2005-0120

Relocation of House

Project Name/Description

RE: Application for Single Family House Relocation, Brewer Street, ID # 2005-0120

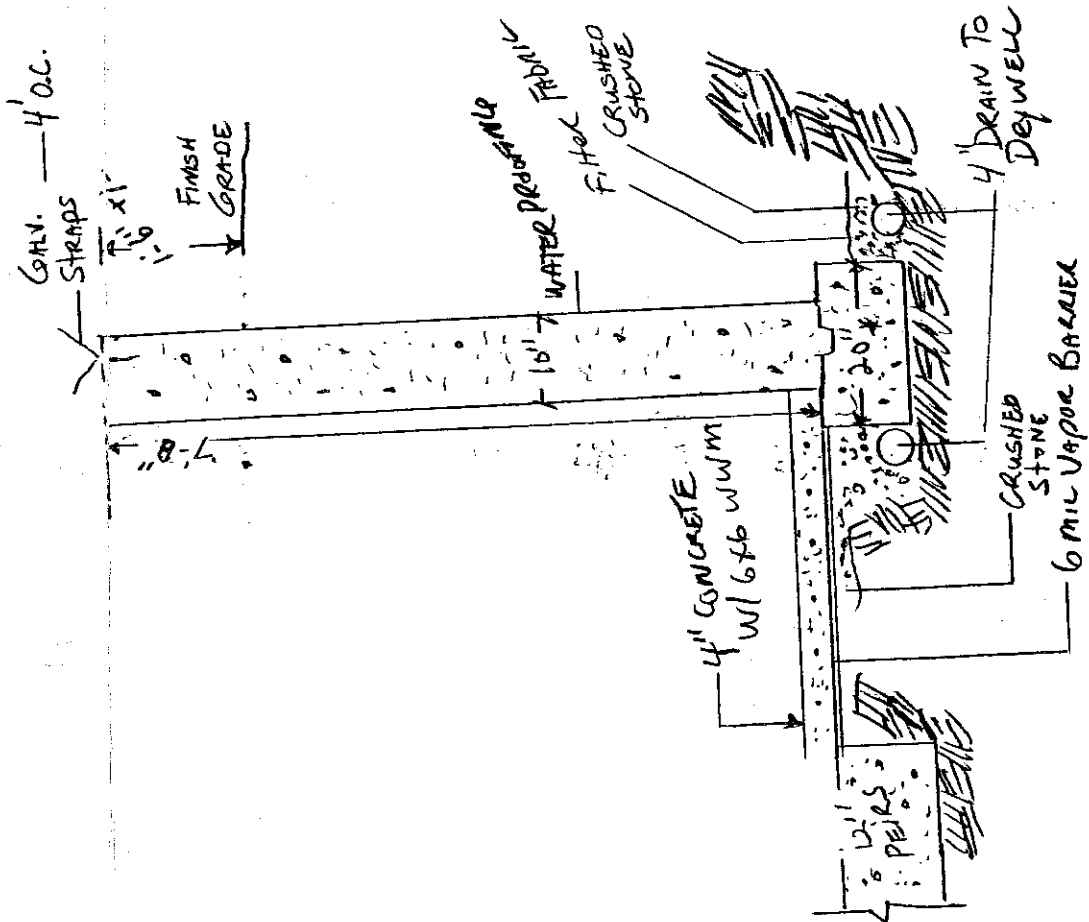
1. 4 parking spaces, 9'x19' each, are required (2 per unit). Please add 4th space to the site plan. Note: parking in the R-5 zone must be outside of the front setback.
2. Relating to item #1, it may be possible to add the 4th space in front of the garage and eliminate the proposed curb cut and paved driveway in front of the new building. Please consider.
3. Please show proposed topography/grading on your site plan.
4. Add erosion control (silt fence) as applicable.
